BCA COMPLIANCE ASSESSMENT REPORT

RPAC REVIEW FOR ST CATHERINE'S SCHOOL

26 ALBION STREET, WAVERLY NSW 2024

DATE ► 28 JULY 2014
PREPARED FOR ► SANDRICK PROJECT DIRECTIONS
REPORT No. ► 5053 Rev 01
PREPARED BY ► AE&D

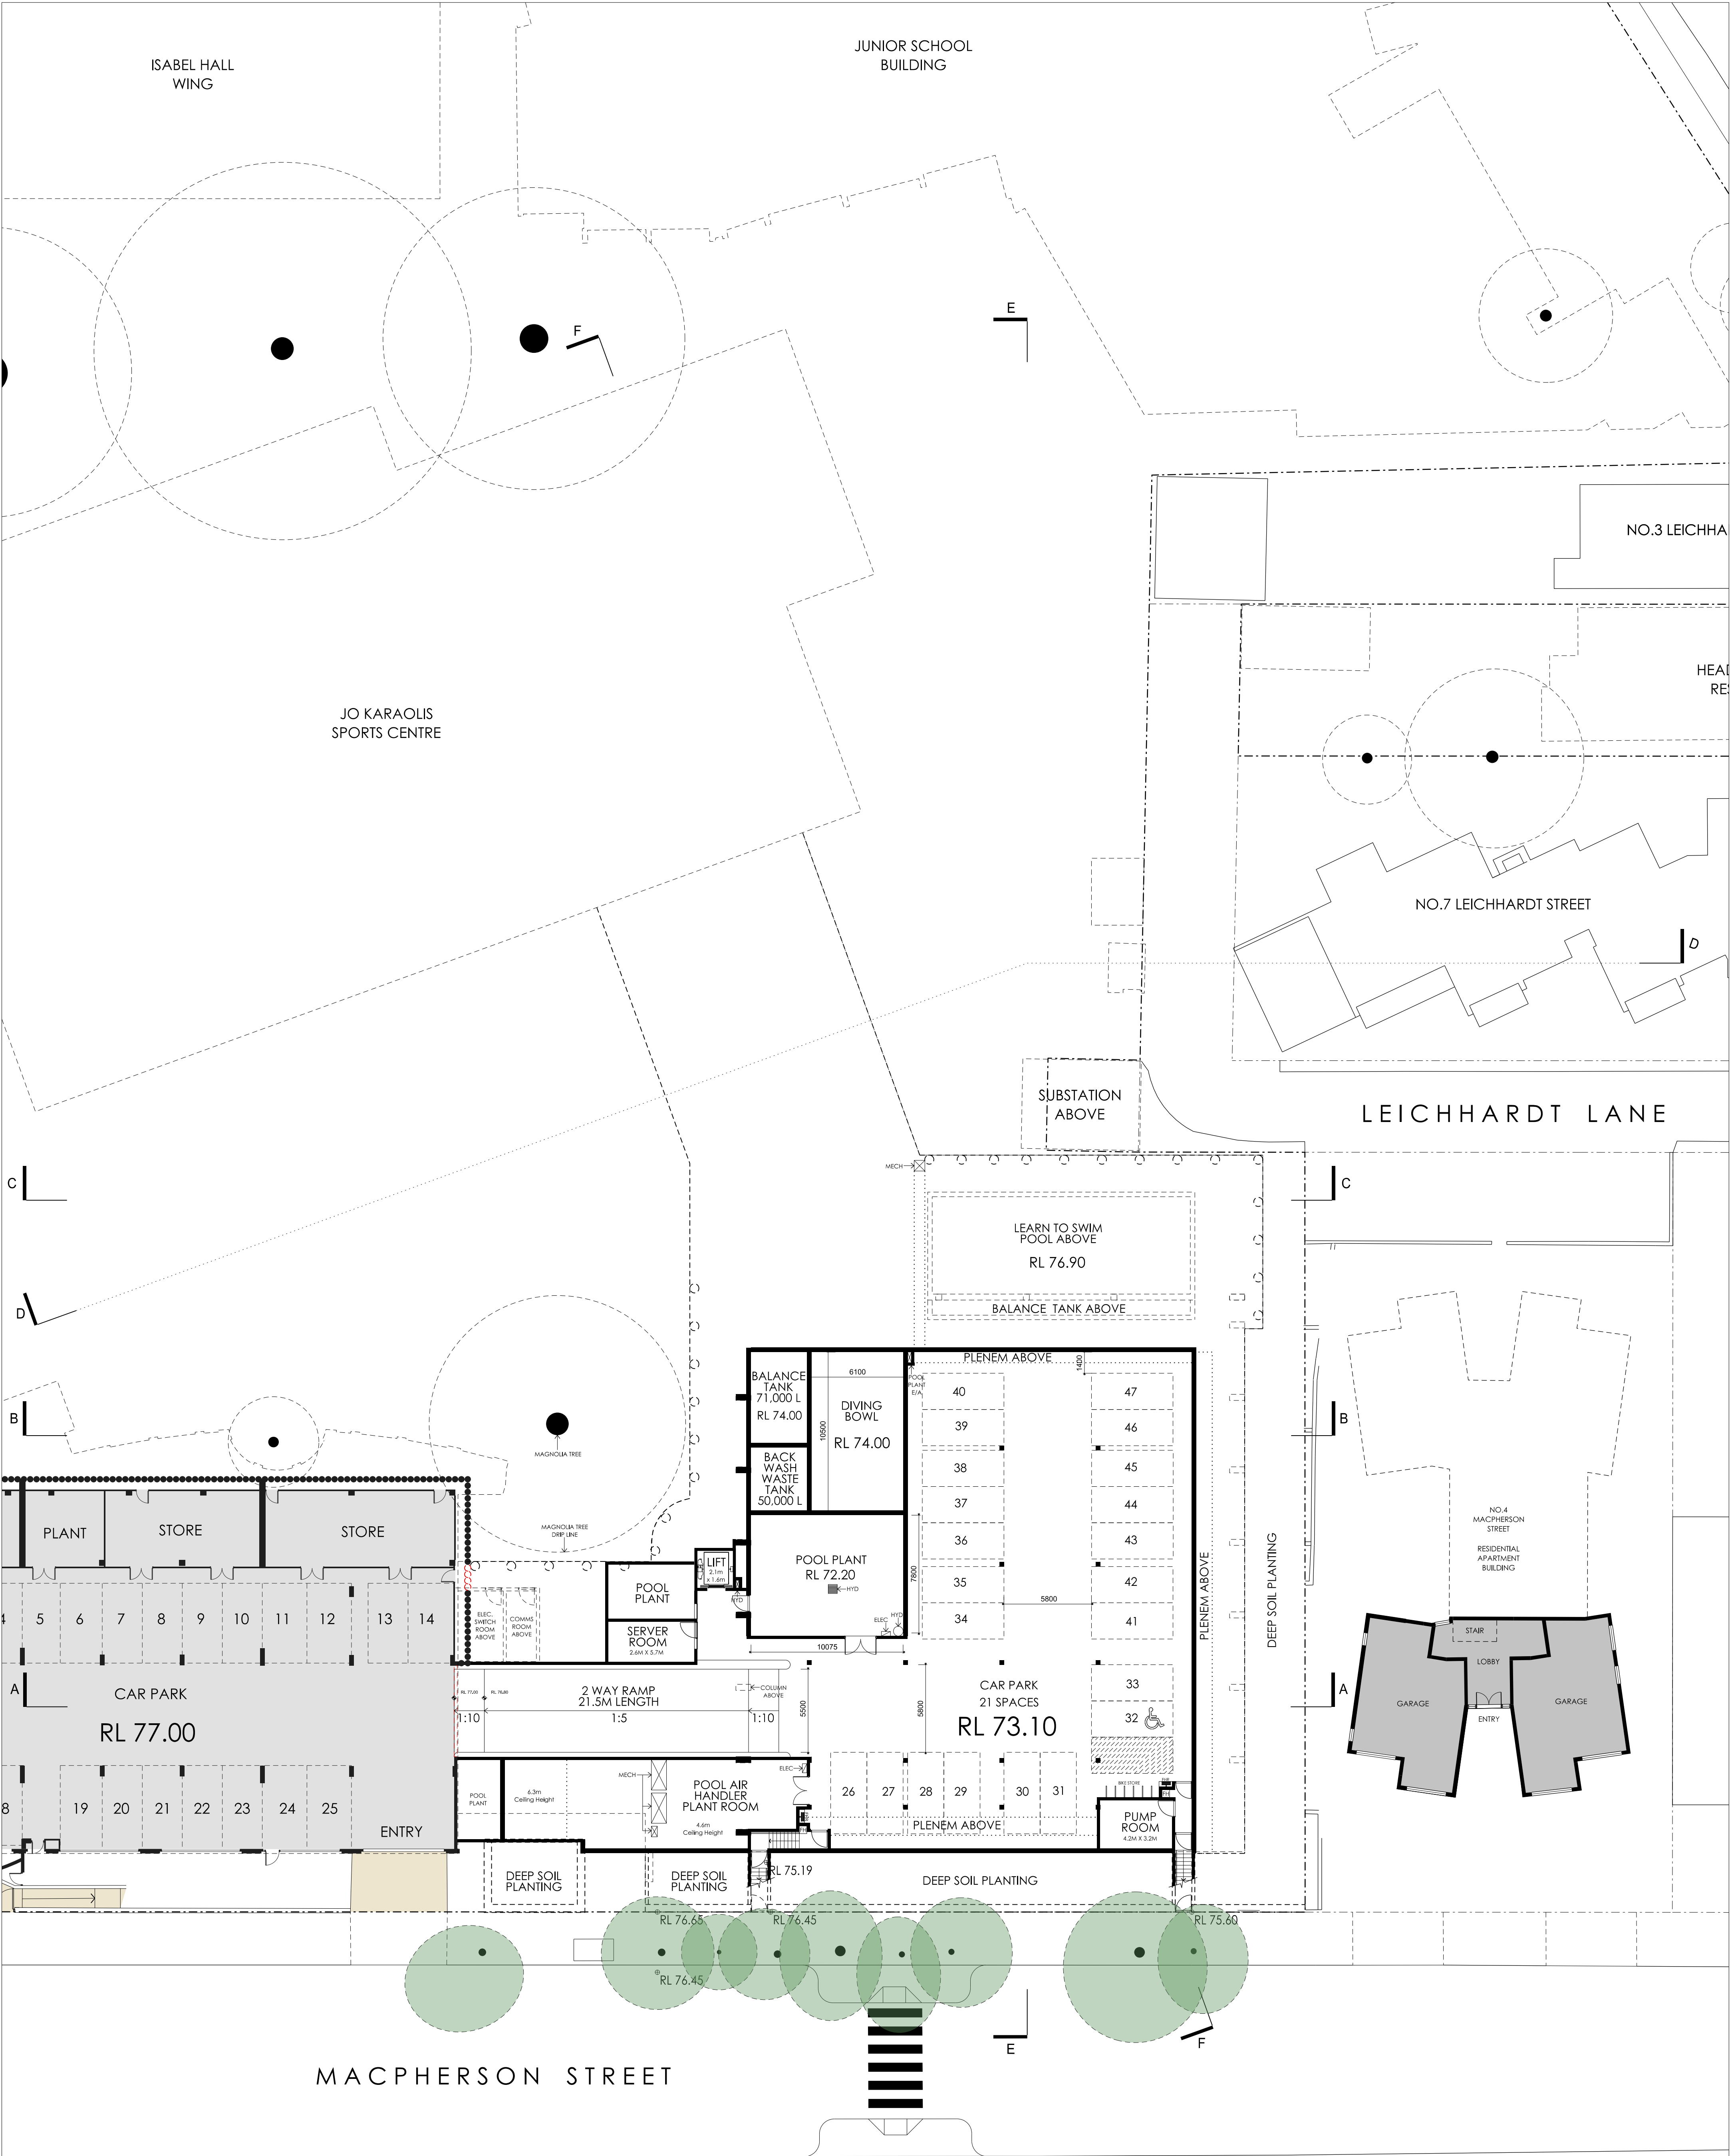
BCA Clause	Deemed-to-Satisfy Provision to be addressed
	egress at level 6 also.
<p>D1.4 Exit travel distances</p>	<p>The distances of travel are currently excessive as follows:</p> <ol style="list-style-type: none"> 1. Level 2 - There is up to 59m travel distance to an alternate exit from the furthest point of the swimming pool (large), on the eastern side. This issue is to be addressed via a performance based solution, based on the low fuel loads within a swimming pool area. 2. Level 2- from the rear of the change rooms for the pool it is more than 20-m to a point of choice (approximately 25-m). This will be addressed via a performance based solution. 3. Level 3 – it is more than 20-m to a point of choice from the weights room to the stair off the green room, (approximately 23-m). We also note that there is an egress stair down to level 2, that potentially could be used, however the discharge point of the stair is more than 20-m from a door leading to open space. This will be addressed via a performance based solution. 4. Level 4 – Egress from the east side of the multipurpose hall on level 4 is greater than 20m to a point of choice (should the operable wall be in use) unless the operable wall has compliant swing doors for exit purposes at the eastern end, or a performance based solution is developed to address this issue. 5. Level 5 – There is an extended travel distance issues from the boardroom, however a performance based solution is proposed to allow occupants to egress into the Dame Joan building.

<p>D1.5 Distance between alternative exits</p>	<p>The distance between alternative exits on level 2 (measured around the east side of the swimming pool) is approximately 118-m in lieu of 60-m maximum (when measured through the point of choice). A performance based solution is required to address this issue.</p>
<p>D1.6 Dimensions of exits and paths of travel to exits</p> <p><i>NSW D1.6(f)(vi)and(i)</i></p>	<ul style="list-style-type: none"> • Egress widths on the eastern external side of the building for the theatre are currently not in accordance with the deemed to satisfy provisions, as the required cumulative egress width is not proposed (currently a 1-m wide egress path has been provided). The provision of egress width to the eastern side of the building is to be the subject of assessment by a fire engineer, based on active fire systems including fast response sprinkler protection and smoke exhaust. • The egress stair from the level 2 pool area reduces in width when it reaches level 3, this reduction in width of 1-m will be addressed via a performance based solution.

BCA DEEMED-TO-SATISFY PROVISION	Complies	Does Not Comply	NA or Informational	Compliance Required	COMMENTS
					<p>2. Level 2- from the rear of the change rooms for the pool it is more than 20-m to a point of choice (approximately 25-m). This will be addressed via a performance based solution.</p> <p>3. Level 3 – it is more than 20-m to a point of choice from the weights room to the stair off the green room, (approximately 23-m). We also note that there is an egress stair down to level 2, that potentially could be used, however the discharge point of the stair is more than 20-m from a door leading to open space. This will be addressed via a performance based solution.</p> <p>4. Level 4 – Egress from the east side of the multipurpose hall on level 4 is greater than 20m to a point of choice (should the operable wall be in use) unless the operable wall has compliant swing doors for exit purposes at the eastern end, or a performance based solution is developed to address this issue.</p> <p>5. Level 5 – There is an extended travel distance issues from the boardroom, however a performance based solution is proposed to allow occupants to egress into the Dame Joan building.</p>

D1.5 Distance between alternative exits		X			The distance between alternative exits on level 2 (measured around the east side of the swimming pool) is approximately 118-m in lieu of 60-m maximum (when measured through the point of choice). A performance based solution is required to address this issue.
D1.6 Dimensions of exits and paths of travel to exits <i>NSW D1.6(f)(vi)and(i)</i>		X		X	<ul style="list-style-type: none"> All paths of travel are to be not less than 1 metre clear width. All doorways within the public areas of the entertainment venue are to be a minimum of 1-m clear width and 1980-mm clear height. All other doorways to be not less than 750mm (clear of door hardware) as per D1.6(f) and 1980-mm clear height, other than doors required for access for people with disabilities as per Part D3 (see separate access consultant's report – i.e. 850-mm clear for access). Egress widths on the eastern external side of the building for the theatre are currently not in accordance with the deemed to satisfy provisions, as the required cumulative egress width is not proposed (currently a 1-m wide egress path has been provided). The provision of egress width to the eastern side of the building is to be the subject of assessment by a fire engineer, based on active fire systems including fast response sprinkler protection and smoke exhaust. The egress stair from the level 2 pool area reduces in width when it reaches level 3, this reduction in width of 1-m will be addressed via a performance based solution.

A.101

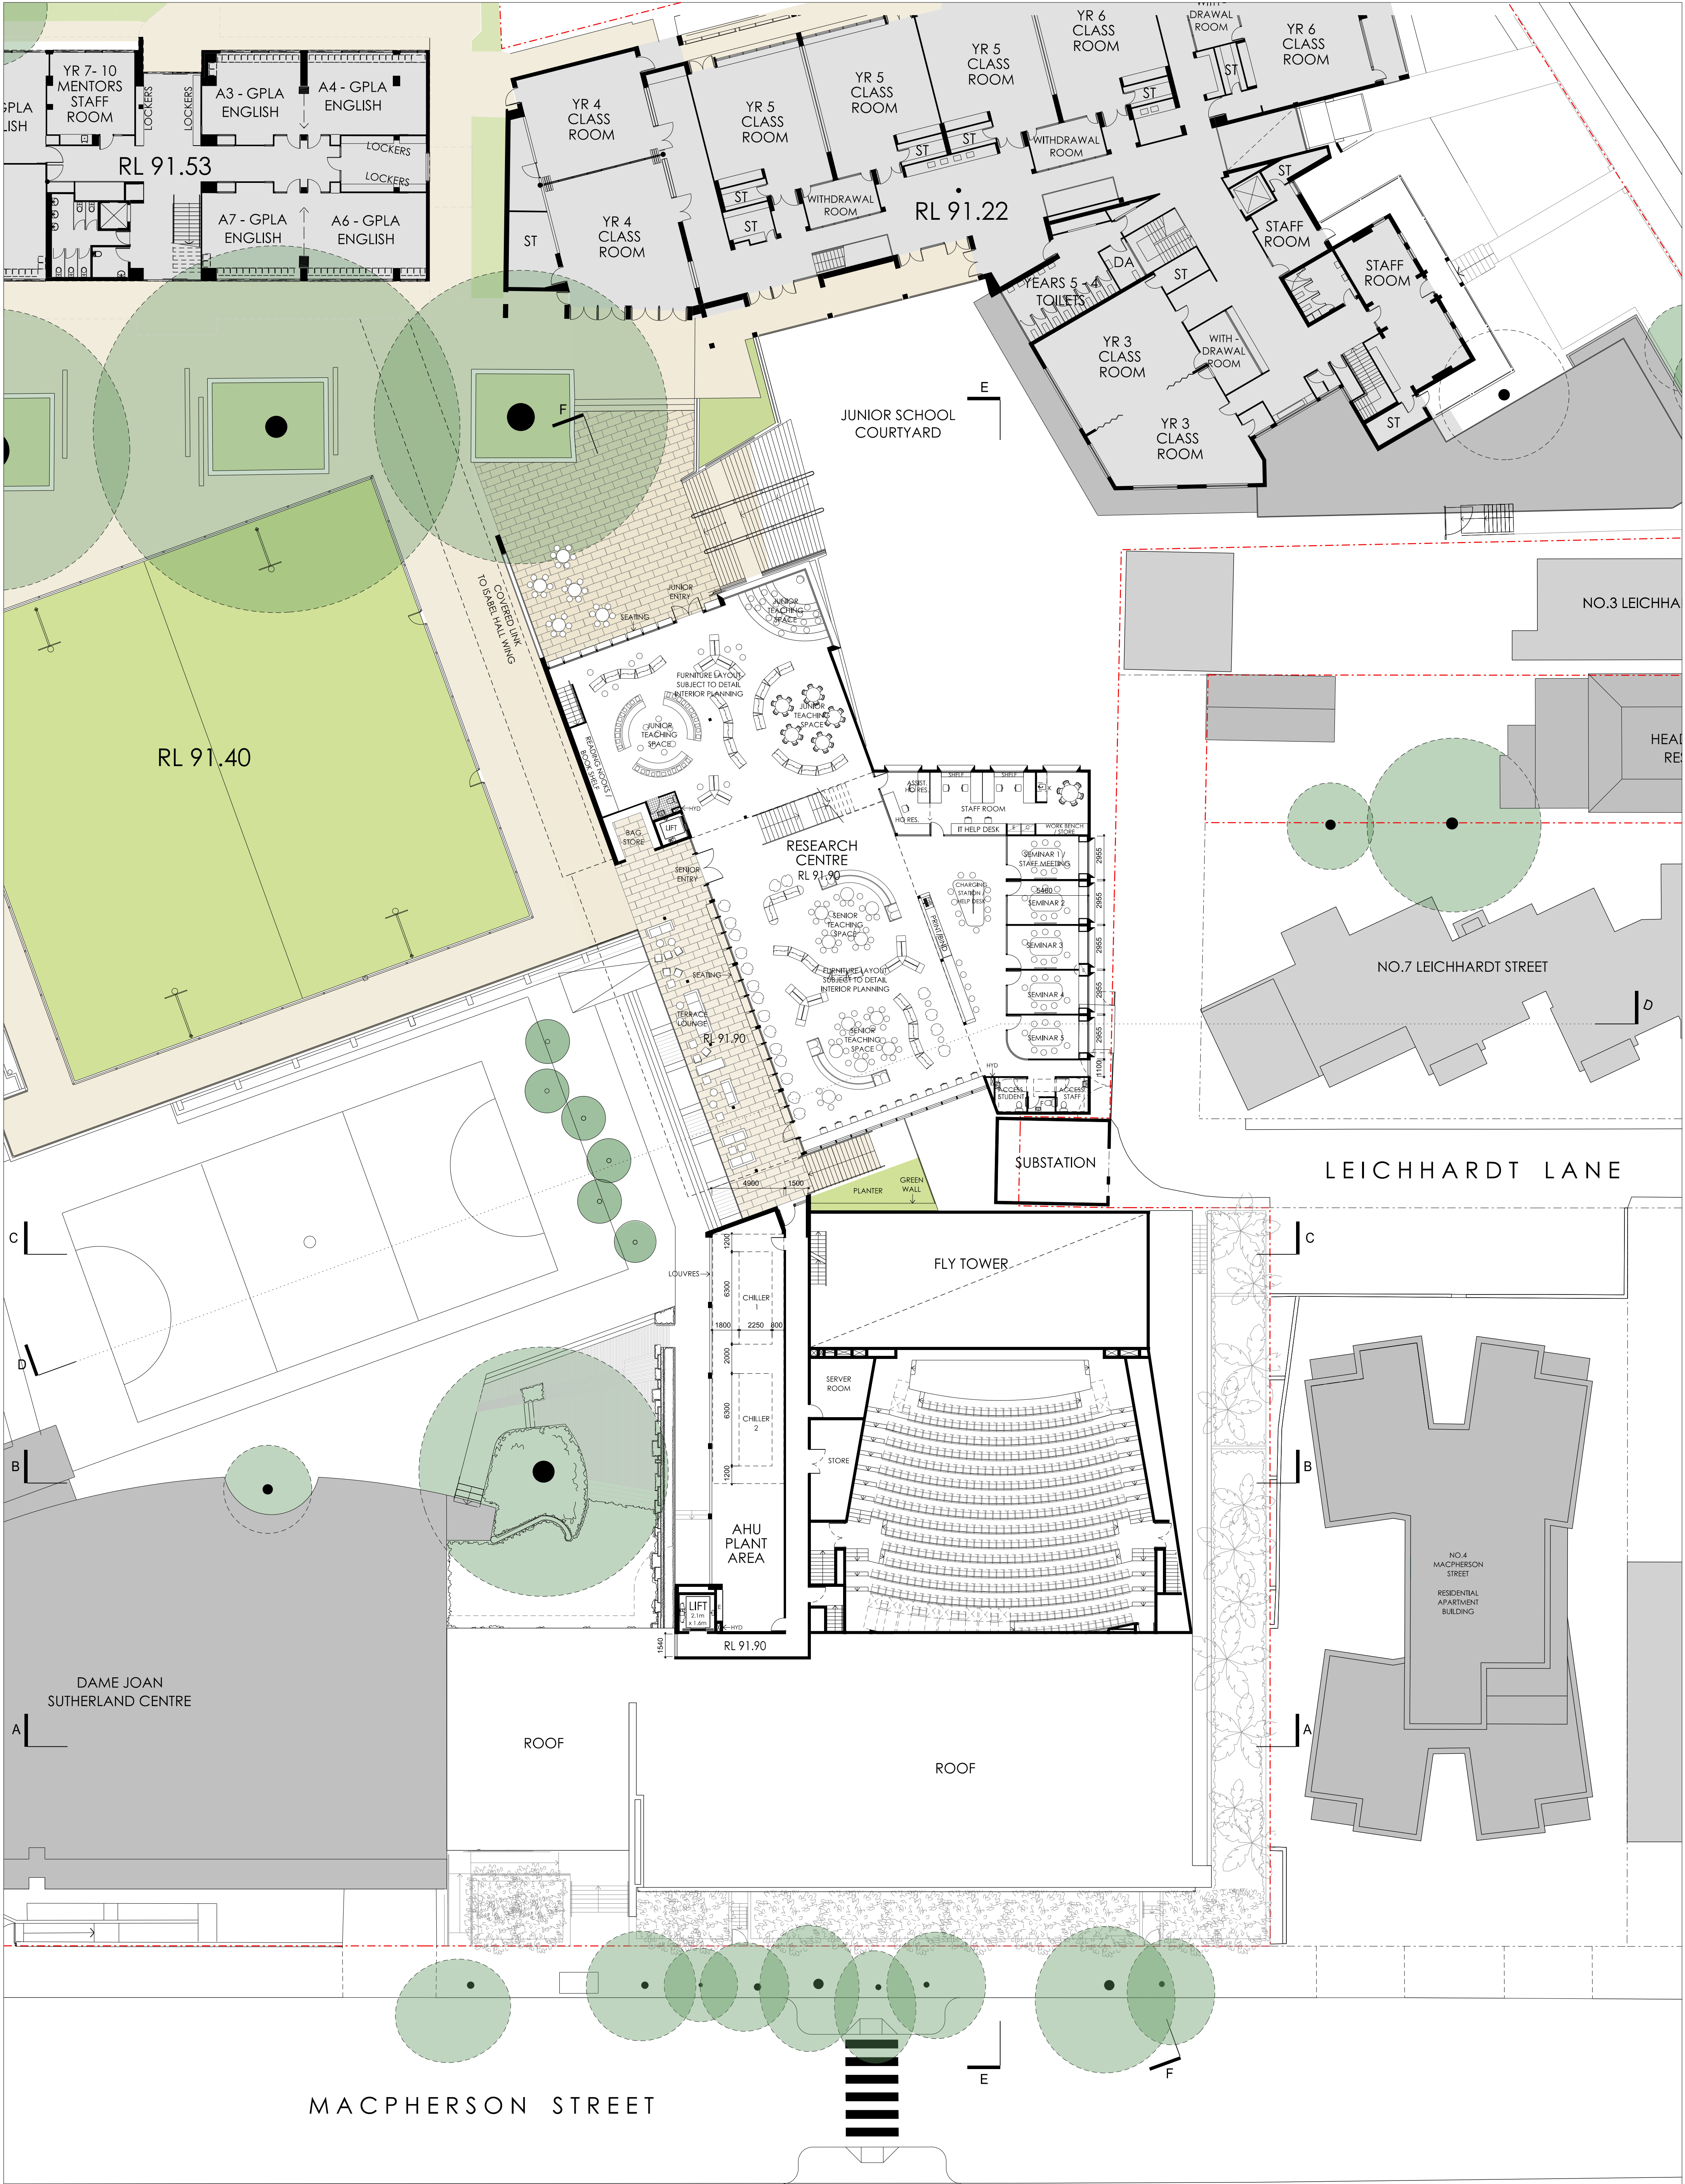
<p>D1.9 Travel by non-fire-isolated stairways or ramps</p>	<ul style="list-style-type: none"> • When occupants reach the base of the stairs at level 4, underneath the research centre, they do not discharge into a location where they are within 20-m of a door that opens to a road or open space, as egress to the east of the building at this level leads occupants into a covered area which is more than 20-m in length before open space is achieved, to the west is a courtyard area which has a pathway between the courtyard and the street that is not open to the sky and requires occupants to pass beneath an overhead section of an existing adjacent building. As such a performance based solution is proposed to address this issue. • The non-fire-isolated stairway adjacent to the green room serving the

BCA Clause	Deemed-to-Satisfy Provision to be addressed
	<p>level 3 parts of the entertainment venue discharges at level 4 at a location that is more than 20m from the road/open space contrary to this clause. As such a performance based solution is proposed to address this issue.</p> <ul style="list-style-type: none"> The egress stair from the northern end of the pool area leads up to level 2, however there is no direct landing connection between this stair and the stair from level 3 up to level 4. As such this issue will be addressed via a performance based solution.
<p>D1.10 Discharge from exits <i>Note NSW D1.10</i></p>	<ul style="list-style-type: none"> The path of travel between the discharge point of the exits and the street must be via a gradient not steeper than 1:8 or stair compliant with the BCA. The path of travel following discharge from the level 4 entertainment venue requires occupants to pass beneath the building (under the research area) to reach a road. This will be addressed via a performance based solution. The discharge from the Jo Karaolis Sports Centre exits will now necessitate occupants to pass beneath the research centre undercroft or via a covered link adjacent the chapel, rather than to open space. This will be addressed via a performance based solution. The egress from the electrical room in the west side of the car park area is into the Dame Joan carpark rather than to a road or open space. This will be addressed via a performance based solution.

BCA DEEMED-TO-SATISFY PROVISION	Complies	Does Not Comply	NA or Informational	Compliance Required	COMMENTS
D1.8 External stairways or ramps in lieu of fire-isolated exits			X		Not applicable. There are no external stairs being used in lieu of fire isolated exits.
D1.9 Travel by non-fire-isolated stairways or ramps		X			<ul style="list-style-type: none"> When occupants reach the base of the stairs at level 4, underneath the research centre, they do not discharge into a location where they are within 20-m of a door that opens to a road or open space, as egress to the east of the building at this level leads occupants into a covered area which is more than 20-m in length before open space is achieved, to the west is a courtyard area which has a pathway between the courtyard and the street that is not open to the sky and requires occupants to pass beneath an overhead section of an existing adjacent building. As such a performance based solution is proposed to address this issue. The non-fire-isolated stairway adjacent to the green room serving the level 3 parts of the entertainment venue discharges at level 4 at a location that is more than 20m from the road/open space contrary to this clause. As such a performance based solution is proposed to address this issue. The egress stair from the northern end of the pool area leads up to level 2, however there is no direct landing connection between this stair and the stair from level 3 up to level 4. As such this issue will be addressed via a performance based solution.
